Ms Claire Muir
Town Planning Advisor
Health Infrastructure
1 Reserve Road
St Leonards NSW 2065
12/11/2021

**The Children's Hospital at Westmead - Paediatric Services Building (SSD-10349252)
Request for additional information**

The Department has reviewed the Amendment Report (AR) and Response to Submissions (RtS) submitted for The Children's Hospital at Westmead - Paediatric Services Building (SSD-10349252) and requests that a response be provided to the Council and EPA comments on the documents (attached). You are also asked to address the following:

Scale	1 : 500@A1	Date	19/11/21
Drawn By	LL	Checked By	AF
Project No	19038	Revision	G
Drawing No	CHW-AR-DG-PSB-SSD011

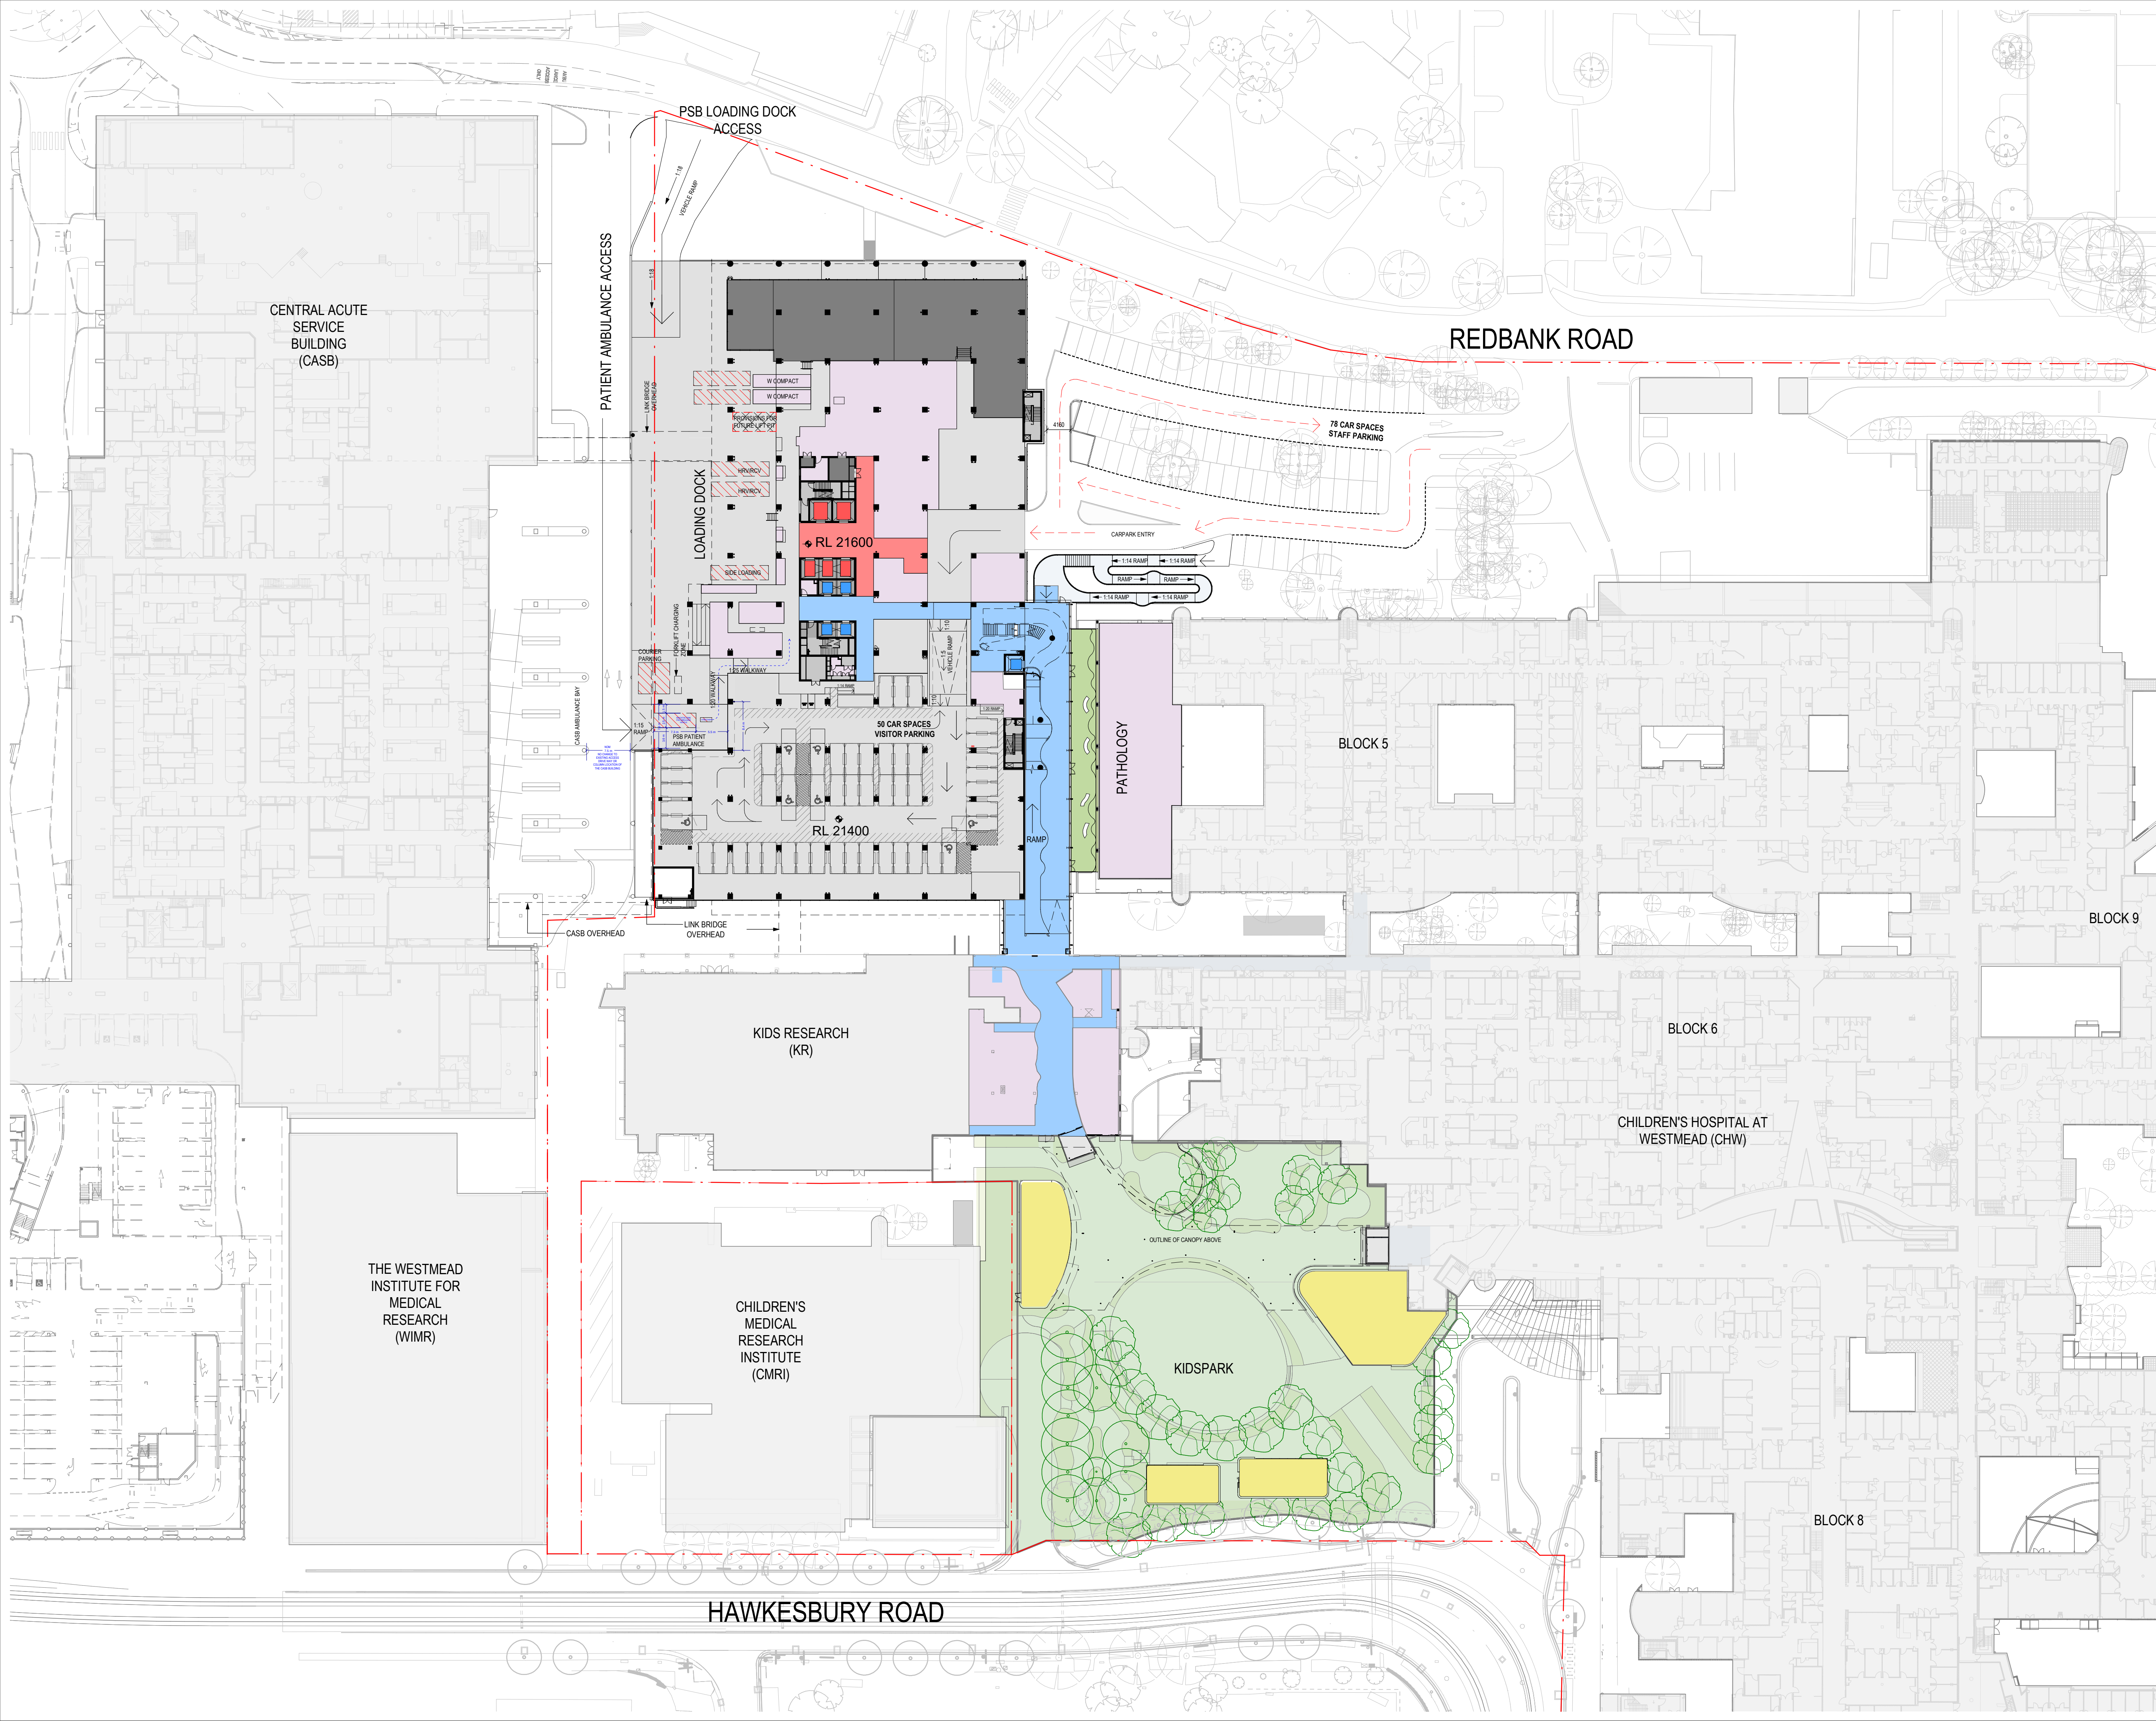
- provide a response to the recommendations of Council, in particular the following:
 - plans be revised to provide shared areas for disabled parking spaces that is compliant with AS2890.6-2009 and include directional pavement arrows/signs to indicate the one-way traffic flow within the carpark.

- the concrete median be removed from Dwg No. CHW-AR-DG-PSB-SSD011 Rev E to facilitate loading manoeuvres.
